Q+A Planning
The Stables
Paradise Wharf
Ducie Street
Manchester
M1 2JN

**RE:PP-12255996 Section 96A Non-Material Amendment at The Heights Academy,
Auckland Drive, Smiths Wood, Solihull**

On behalf of our client Tilbury Douglas Construction Ltd, please find enclosed an application requesting a Non-Material Amendment (NMA) under section 96A of the Town and Country Planning Act 1990 pursuant to application reference **PL/2022/00491/PPFL**.

DRAWING TITLE:
LANDSCAPE GA

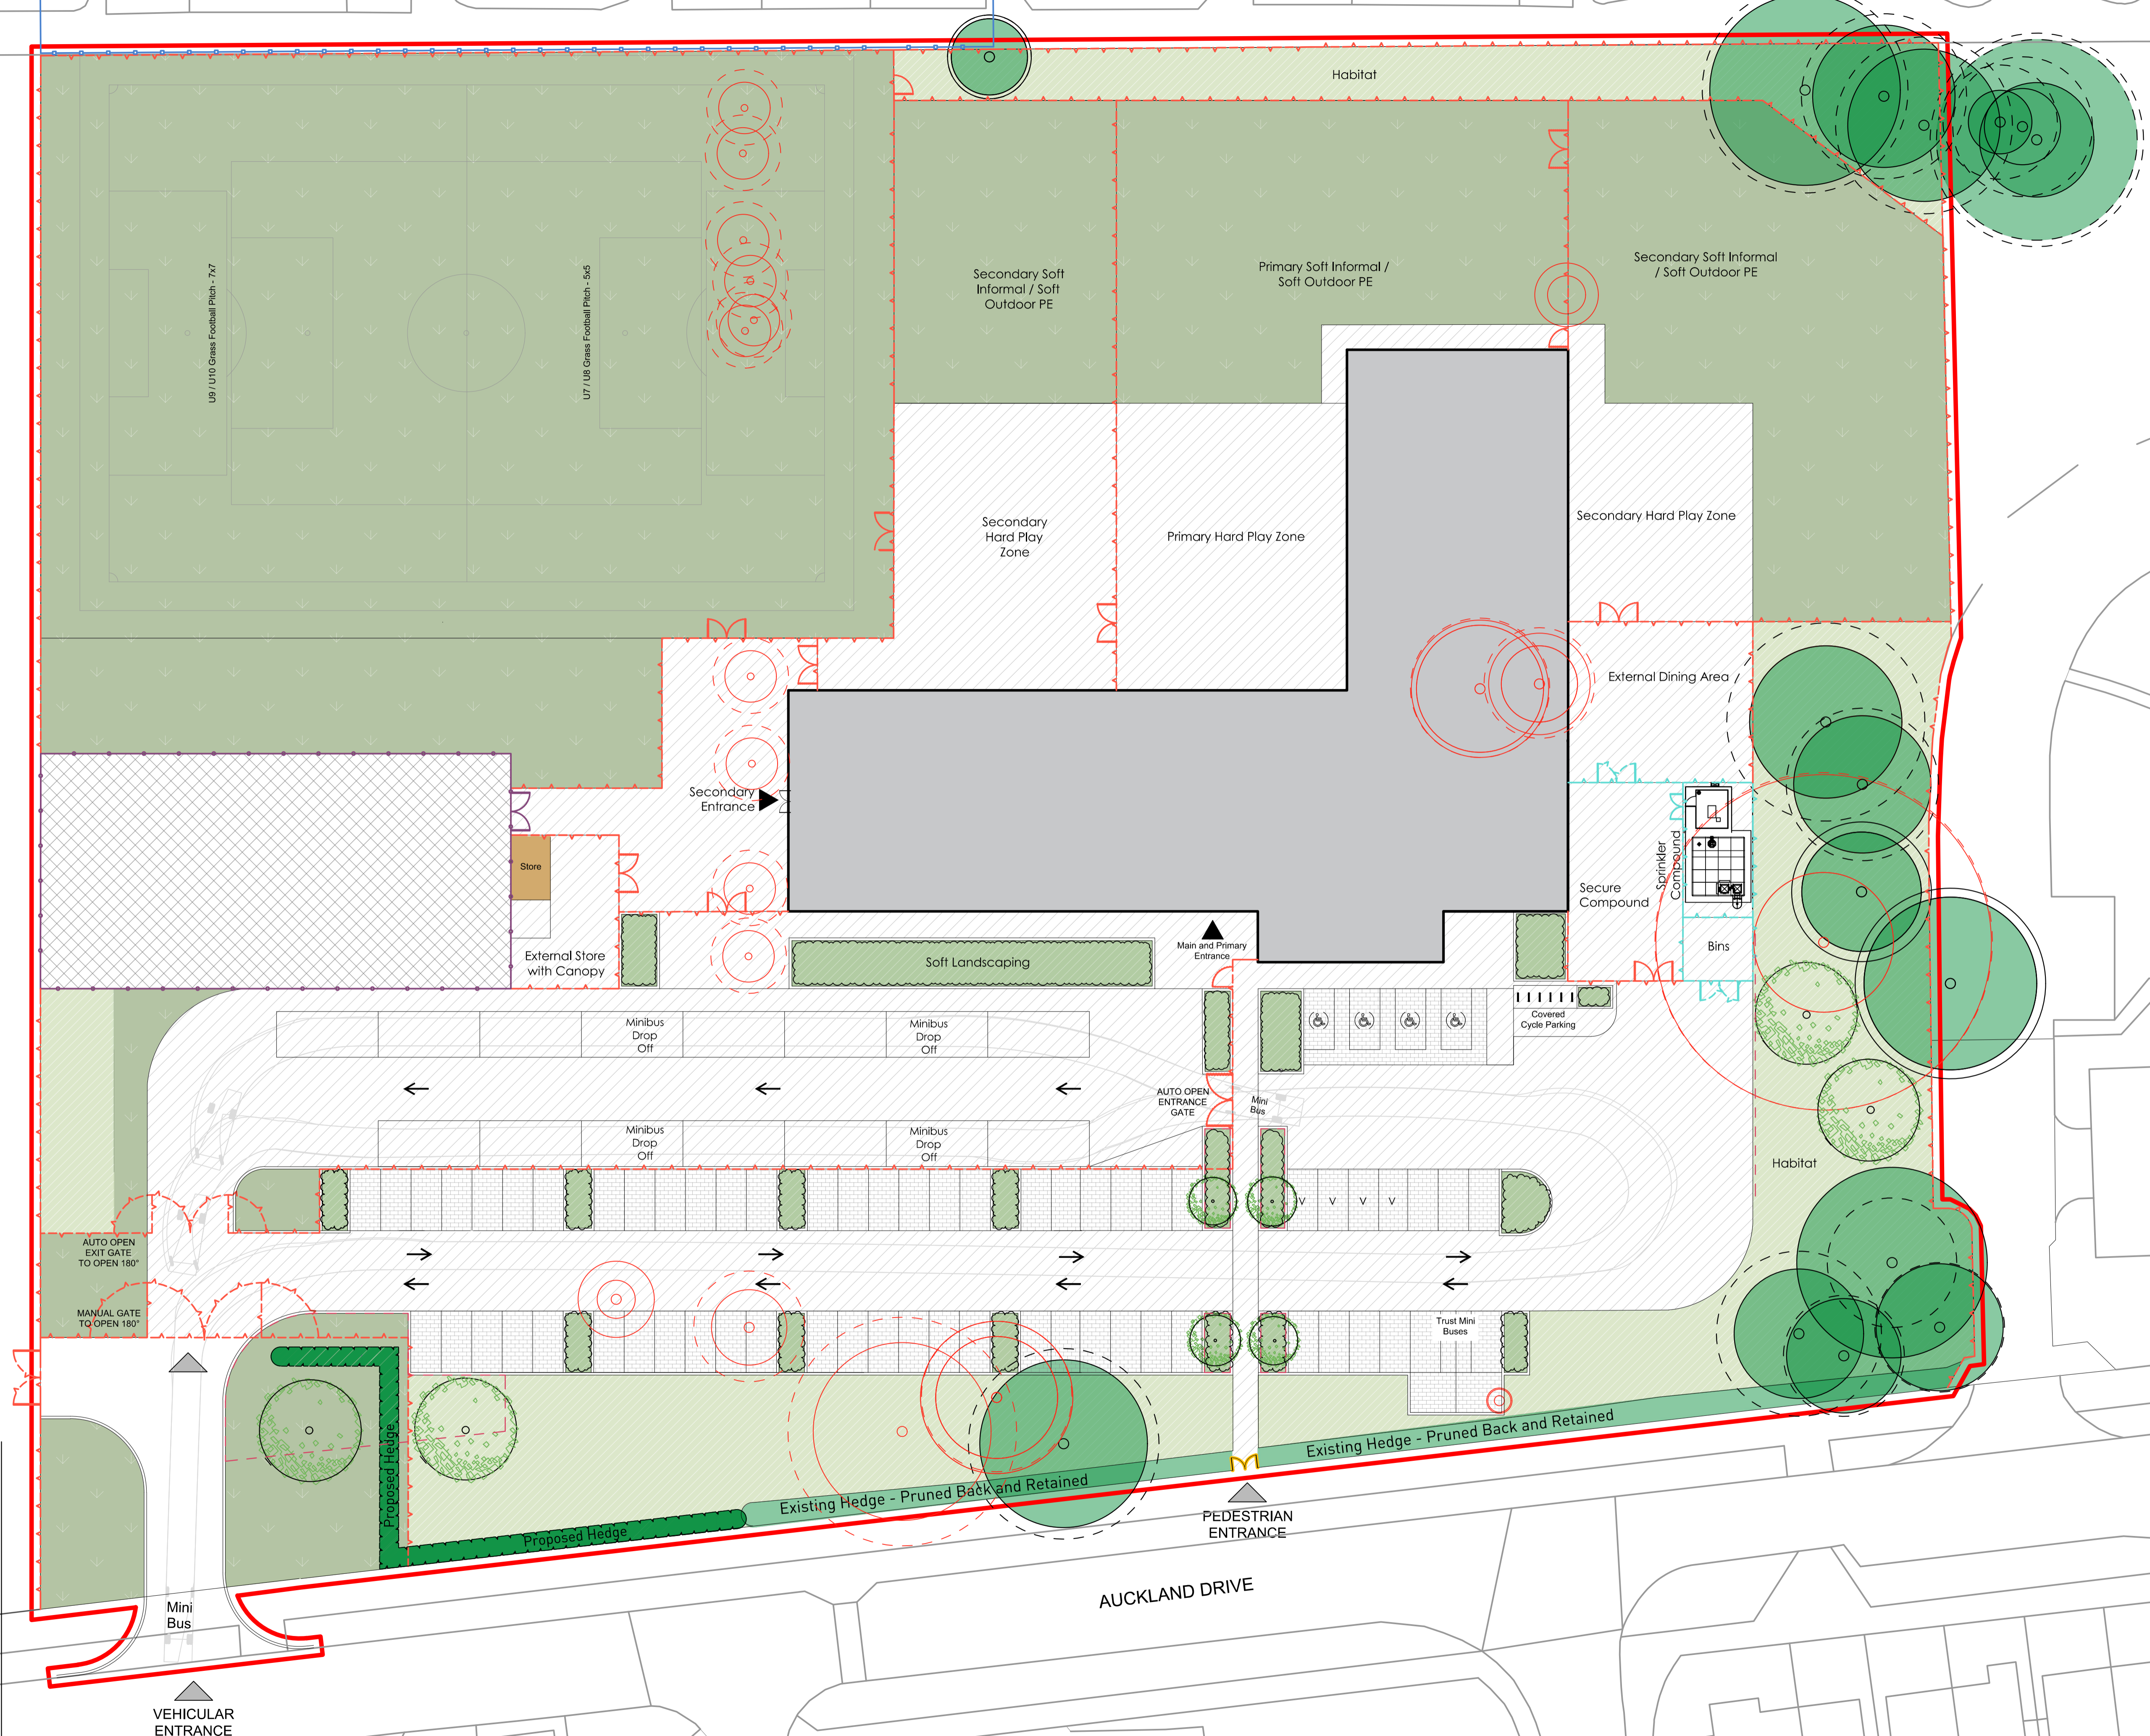
The second requested change relates to minor changes to the approved Landscape GA plan as listed in condition 1 of the decision notice - reference 001478-ADP-00-00-DR-L1900-LANDSCAPE GA-D3 T14.

The changes to the landscape plan are twofold. Firstly, it is proposed to relocate one of the trees to the south of the car parking. Due to the drainage layout requirements, one tree cannot now be satisfactorily accommodated in its approved location and the revised plan shows this relocated to the west. Importantly, the changes proposed relate to the position of the trees only, there is no change to the type, number or total new trees to be provided.

Secondly, it is proposed to reposition part of the front hedgerow there is concern from the school operators regarding security of the entrance gates. Specifically, that the proposed new portion of hedge to the entrance of the school site could create a 'hiding zone' leading to a security risk for children and therefore it is proposed to form a 'dog leg' around the secure gated mini bus entrance to prevent this.
